v3_Site Development Plan.pdf Markup Summary

Subject: Callout
Page Label: [2] 2 HORIZONTAL CONTROL
Author: CDurham
Date: 4/18/2024 2:53:26 PM
Status:
Color: ■
Layer:
Space:

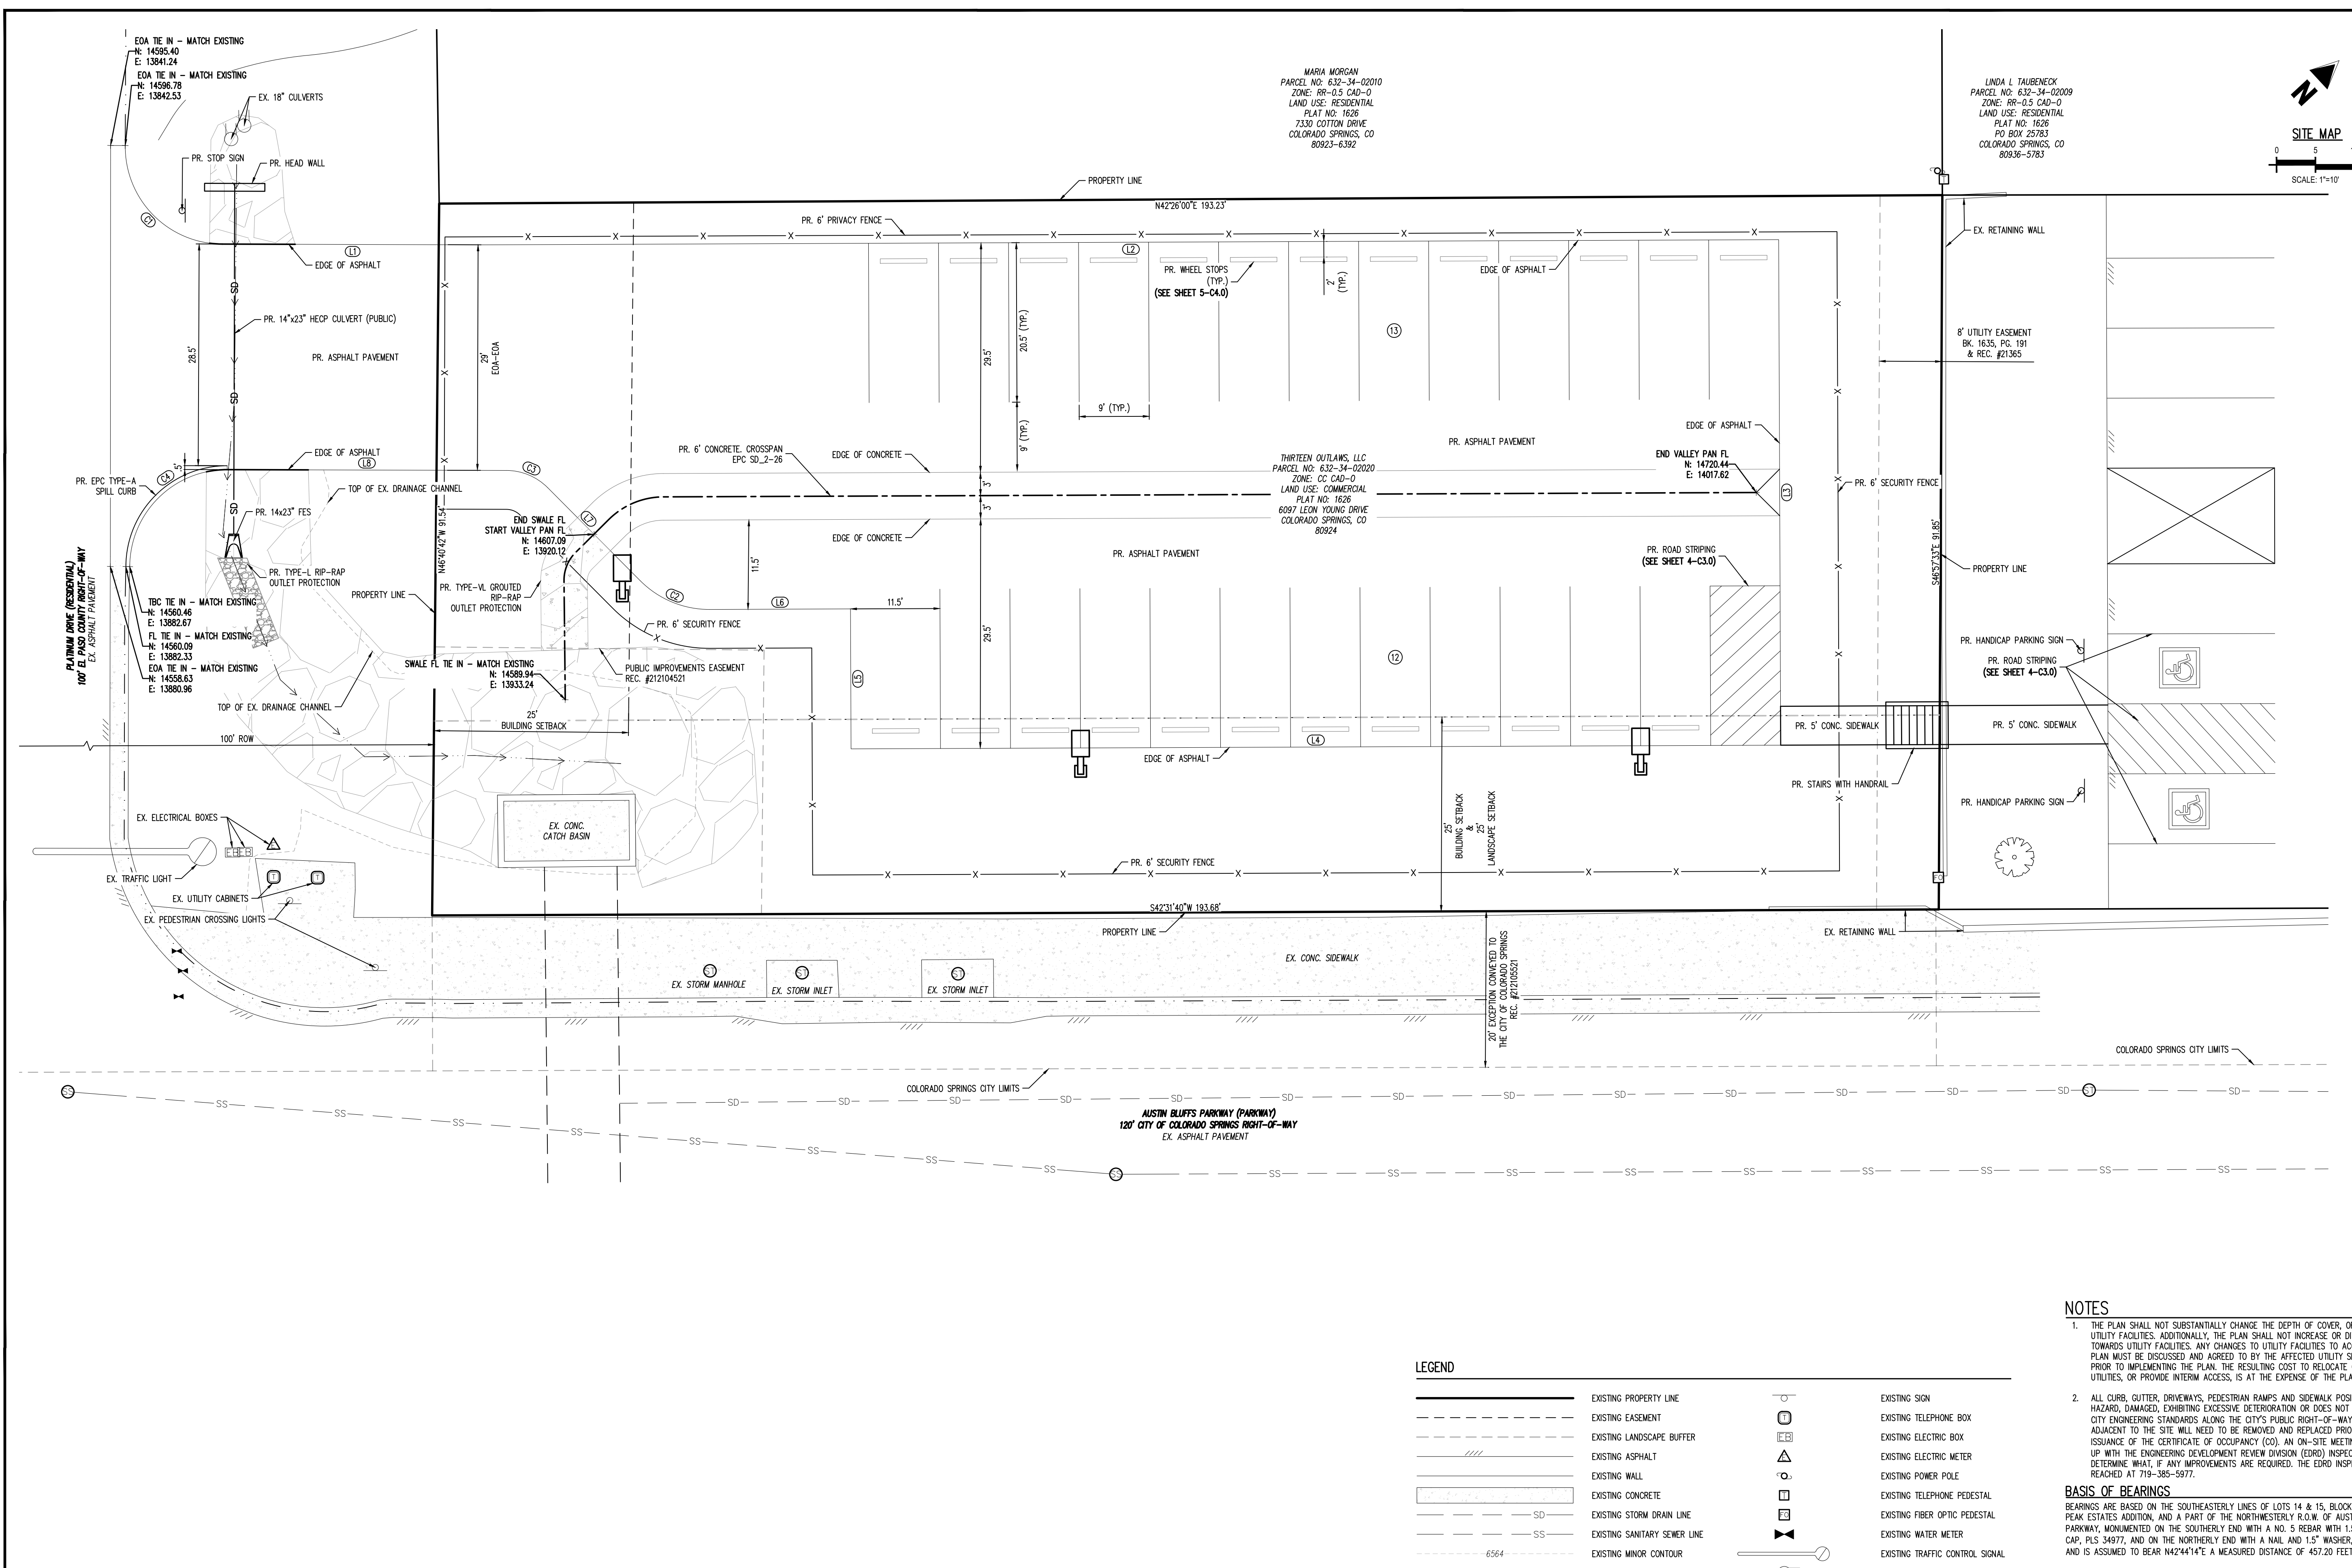
Label what this hatching represents. Provide a detail if needed.

I misspoke on my previous comment and even though in public row, driveway culverts are still considered private. Please revise label to private and the FAE will not be needed.
